Inn at Diamond Cove

To: Chair Hall and Members of the Portland Planning Board
From: Richard Knowland, Senior Planner
Date: January 26, 2010
Re: The Inn at Diamond Cove, Great Diamond Island

A workshop has been scheduled to consider a proposal by The Inn at Diamond Cove, LLC. for a proposed 20 unit residential hotel condominium (hotelminium) on Great Diamond Island. This proposal would renovate the existing Double Barracks building within the parade ground of the Fort McKinley complex on Great Diamond Island. The Double Barracks building is the largest brick building not renovated within the Fort McKinley complex.

SHEET TITLE
SITE LAYOUT & UTILITY PLAN

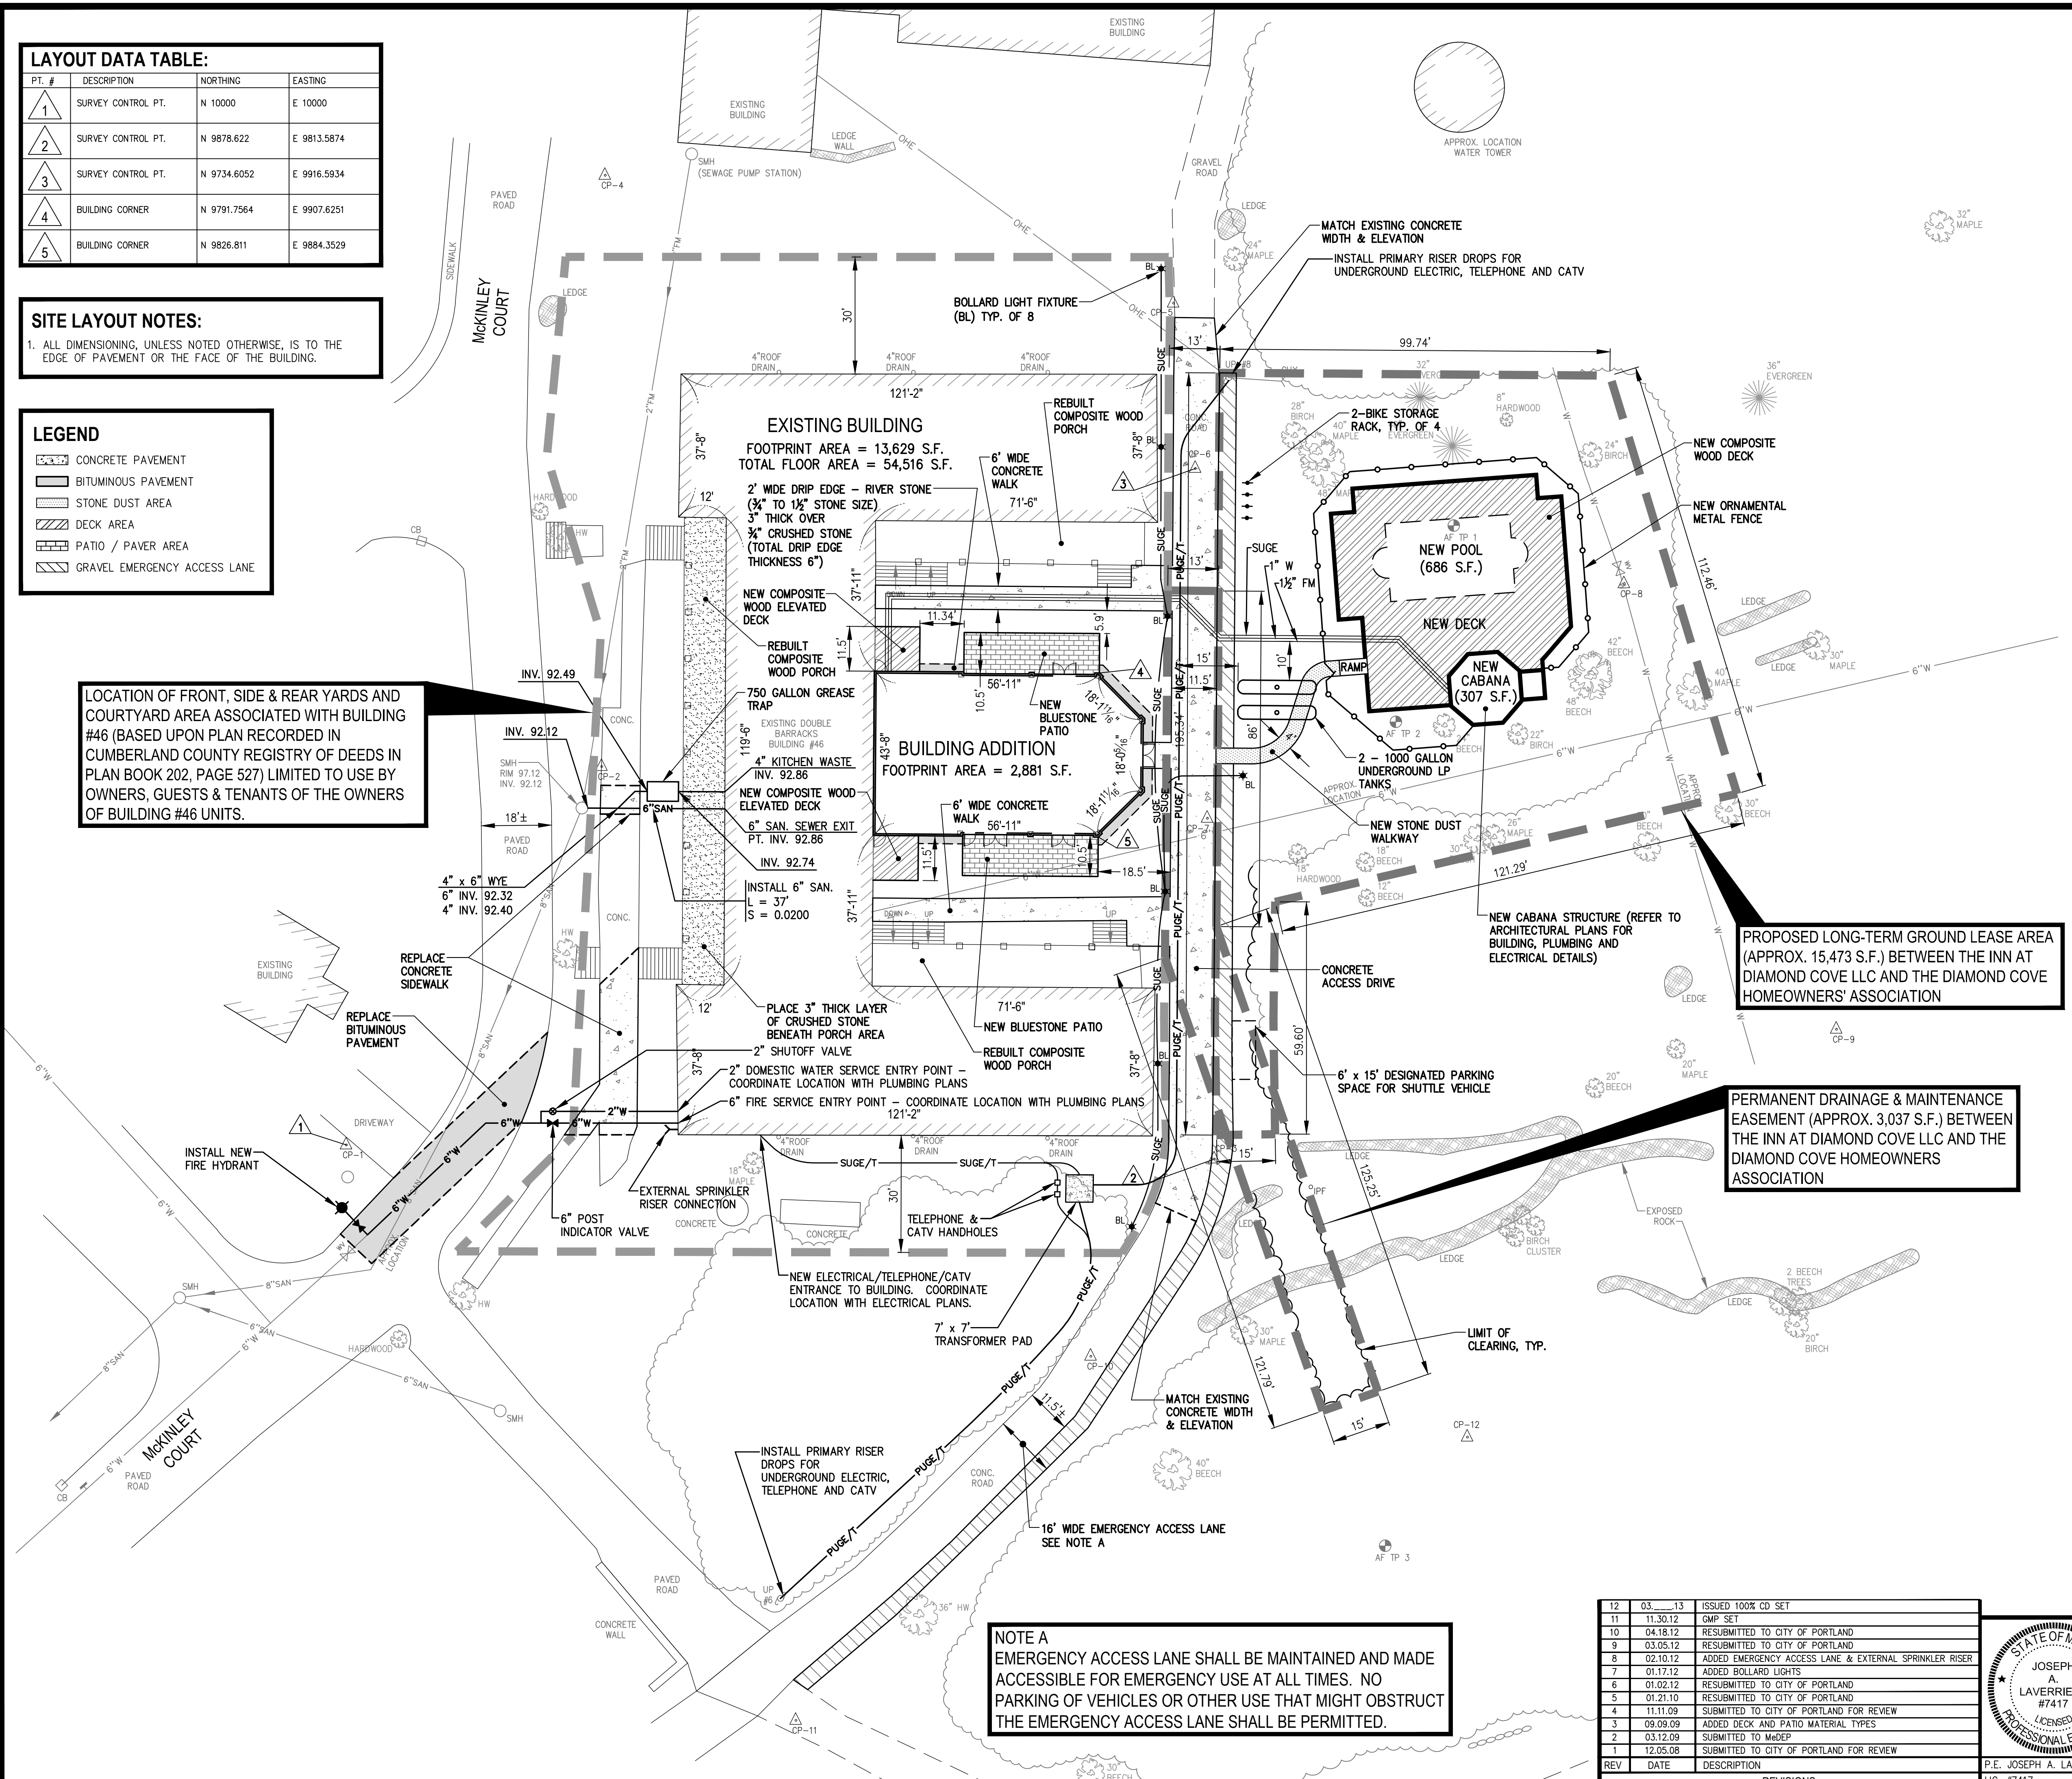
The driveway behind the Double Barracks is about 13 feet wide. Comments from Captain Gautreau indicate the driveway should be a minimum of 16 feet wide for fire access.
